Boston Alternative Energy Facility

Statement of Common Ground between Alternative Use Boston Projects Limited and RSPB

Planning Inspectorate Reference Number: EN010095

Date: 01 March 2022

Plate A1- 3 Mitigation measures proposed for the Habitat Mitigation Area

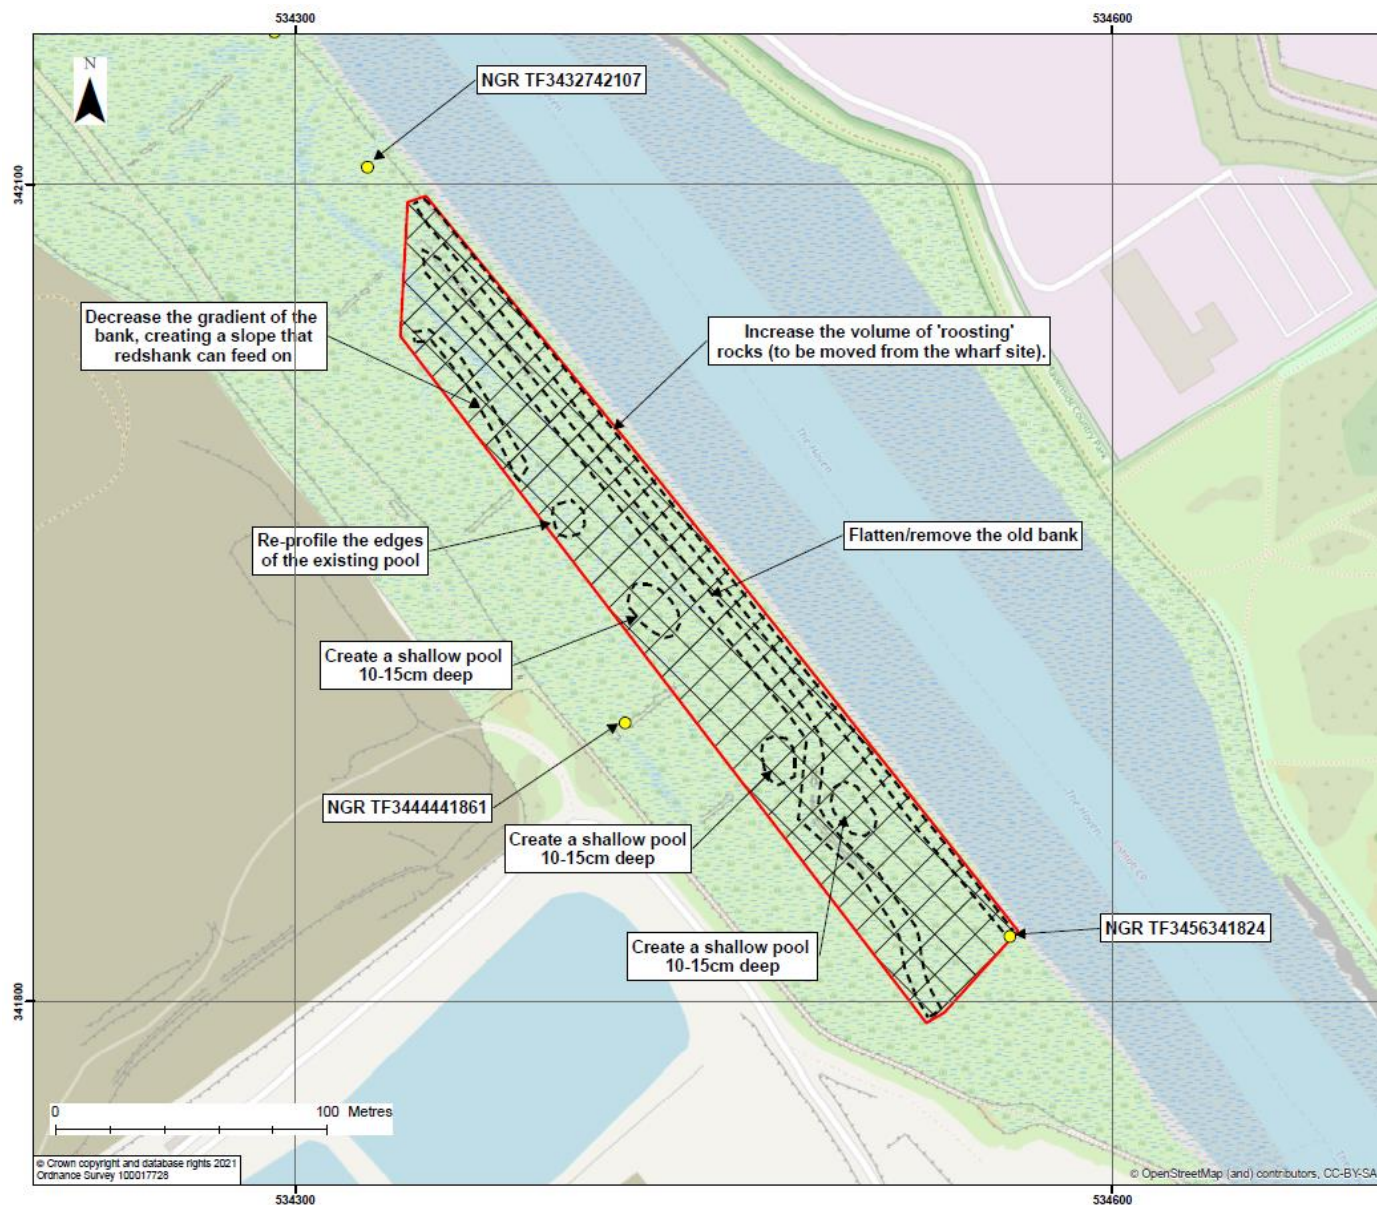
SoCG Reference	Topic	Matter	RSPB's Comment	AUBP's Position	Notes
1.5	Mitigation	The proposed mitigation for the construction, operation and decommissioning phases is appropriate.	Under discussion	Under discussion	<p><u>The RSPB's Position</u> Disagreement over the phrase 'Habitat Mitigation Area'.</p> <p><u>The Applicant's Position</u> The applicant is of the view that this term is correct.</p> <p>See paragraph 1.4.3 for further information.</p>

1.6	Compensation	The proposed compensation for the construction, operation and decommissioning phases is appropriate.	Not agreed	Under discussion	<p><u>The RSPB's Position</u> The effectiveness of measures to compensate for redshank roost at the Application Site:</p> <ul style="list-style-type: none"> • Sufficient evidence has not been provided to demonstrate alternative roost would be ecologically effective; and • Would cause the loss of current feeding habitat within functionally linked land <p>No compensation has been proposed for foraging habitat for waders at the Application Site.</p> <p>The RSPB does not consider sufficient detail is provided in the Applicant's Without Prejudice Derogation Case Compensation</p>

SoCG Reference	Topic	Matter	RSPB's Comment	AUBP's Position	Notes
					<p>Measures document to demonstrate that either of the proposed fields will be effective. There is no location information provided and no detailed plan provided of the habitat that would be created. Whilst the fields may offer potential to deliver a suitable scale of habitat, the RSPB considers substantial work is likely to be needed to secure planning permission and other consents based on our experience of delivering similar habitat creation in the area. There is also detail needed on whether and how water will be secured to deliver the habitat in these areas; this could be a significant issue given the challenge the RSPB has to bring water to Freiston Shore. We also have concerns about land only being secured on a 25 year lease. There is no draft management plan available to understand how the Applicant plans to manage the site in perpetuity. More detail is also needed on the delivery timetable to demonstrate that compensation measures will be functioning prior to construction starting.</p> <p><u>The Applicant's Position</u></p>

SoCG Reference	Topic	Matter	RSPB's Comment	AUBP's Position	Notes
					The Applicant has submitted an updated Without Prejudice Habitats Regulations Assessment Derogation Case: Compensation Measures (Clean) (document reference 9.30(1), REP6-025) at Deadline 6. The fields outlined within this document are the proposed compensation sites which will provide suitable habitat for birds. There are drainage ditches around both sites. Further work on these sites would be undertaken once a decision is made on the requirement for the sites to act as compensation and/or biodiversity net gain. The information provided is appropriate and is consistent with precedent set on other DCOs.
